24 February 2011

**Moolarben Coal Complex Stage 2 \_ Preferred Project Report 08\_135**

I wish to lodge my objection to the Moolarben Coal Complex (MCC) Stage 2 Preferred Project Report (PPR). This proposal falls well short of the environmental requirements that would be necessary to offset and mitigate the prospective water catchment degradation and biodiversity loss emanating from this mine. It fails to provide adequate compensation to the local community and future generations for the scale and impact of the project predicted to endure in excess of 100 years.

Fig 2.5 - MCC Transect 4 - with Drip seepage zone height corrected to 8-12m
PZ129 superimposed (depth to scale - from LOG)

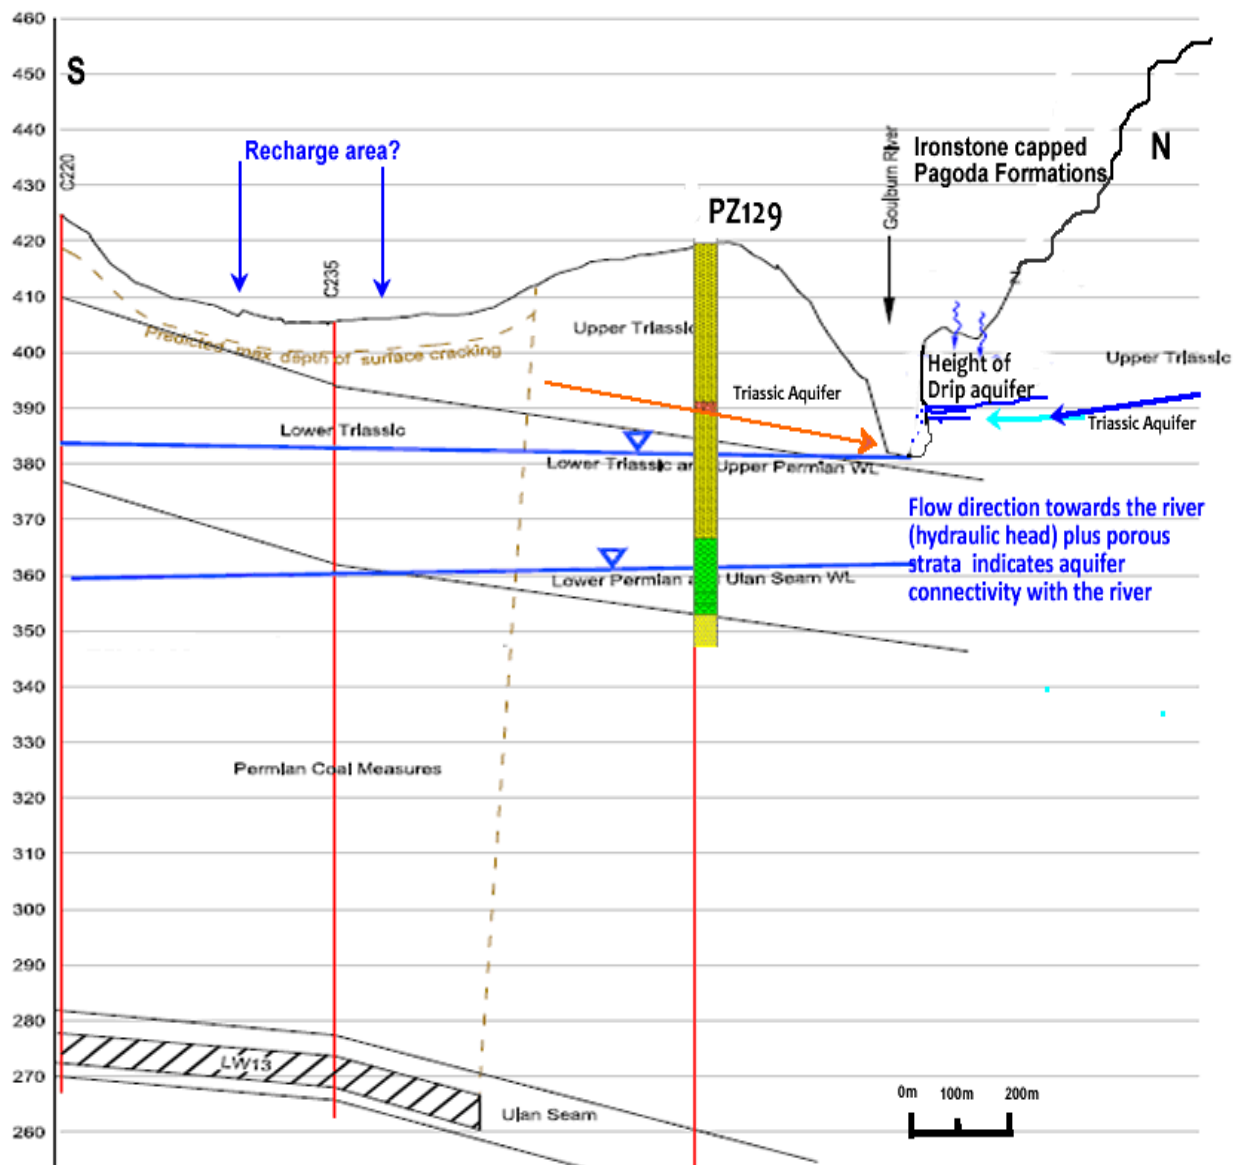
Increased vertical hydraulic permeability due to mine subsidence occurred above UCML underground prior to 2006 and the installation of the wider long wall faces. Table 5.9 (p.48 MCP GIA) shows increasing mine inflows from the 1990s, accelerating in 2000-2002 wet years (from 5.6- 7.7 ML/day). Triassic Bore PZ129 has a hydraulic head range 390-393mAHD (MCC AEMR 2010-11) this is above the level of the river (~382m AHD) indicating groundwater flows towards the River (see Fig2.5).

The GDE referred to as ‘The Drip’ has not been adequately investigated or understood. Local knowledge will confirm that seepage is sustained throughout the severest of droughts; this resilience suggests it is fed by a permanent groundwater source located above the ‘dripping’ discharge area (~ 390 mAHD - halfway up the cliff face). While the aquifer would obviously rely on replenishment from rainfall events, it may also be sustained from upward pressure from joint or fault connecting it to the Triassic aquifer system (Pz129 = 389-392 mAHD) and therefore could be potentially drained if the Triassic Aquifer was depressurised. The water level in hydraulic head of Triassic Bore PZ 129c (opposite The Drip) indicates groundwater flow towards the river.
